Date: 27-Feb-2026
Our Ref: 2025/93525

**TOWN AND COUNTRY PLANNING ACT 1990
TOWN AND COUNTRY PLANNING (GENERAL PERMITTED DEVELOPMENT)
(ENGLAND) ORDER 2015 (as amended), SCHEDULE 2, PART 3, PART MA
NOTIFICATION OF PROPOSED CHANGE OF USE CLASS MA – COMMERCIAL,
BUSINESS AND SERVICE USES TO DWELLINGHOUSES
APPLICATION NUMBER: 2025/93525
AT: ground floor, 2, Bridge Street, Batley, WF17 5NU**

Prior approval of a proposed change of use of a building from commercial, business and service uses to dwellinghouses

(EXISTING)(NORTH EAST) SIDE ELEVATION, 1: 100mm

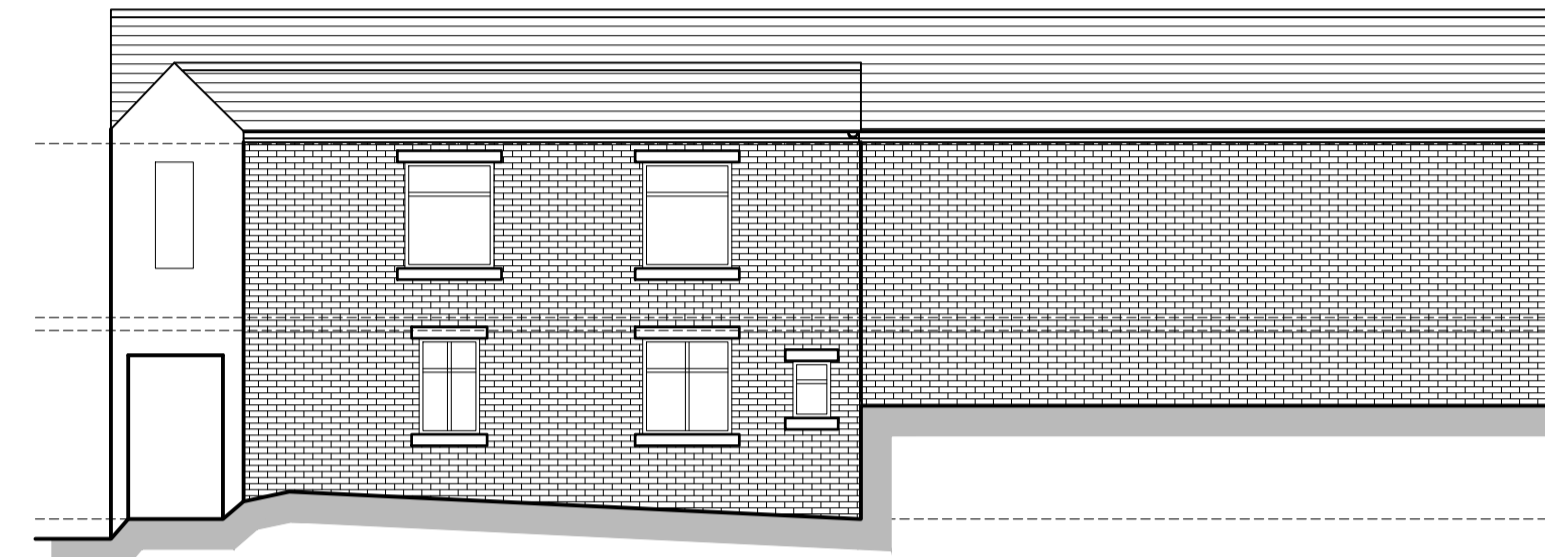
It is considered that not all habitable room windows will receive adequate natural light, particularly the absence of any existing window in the bedroom of the flat located in the north east corner of the ground floor and insufficient light penetrating into the living/kitchen/dining area in the flat located behind the existing solid doors on the east elevation.
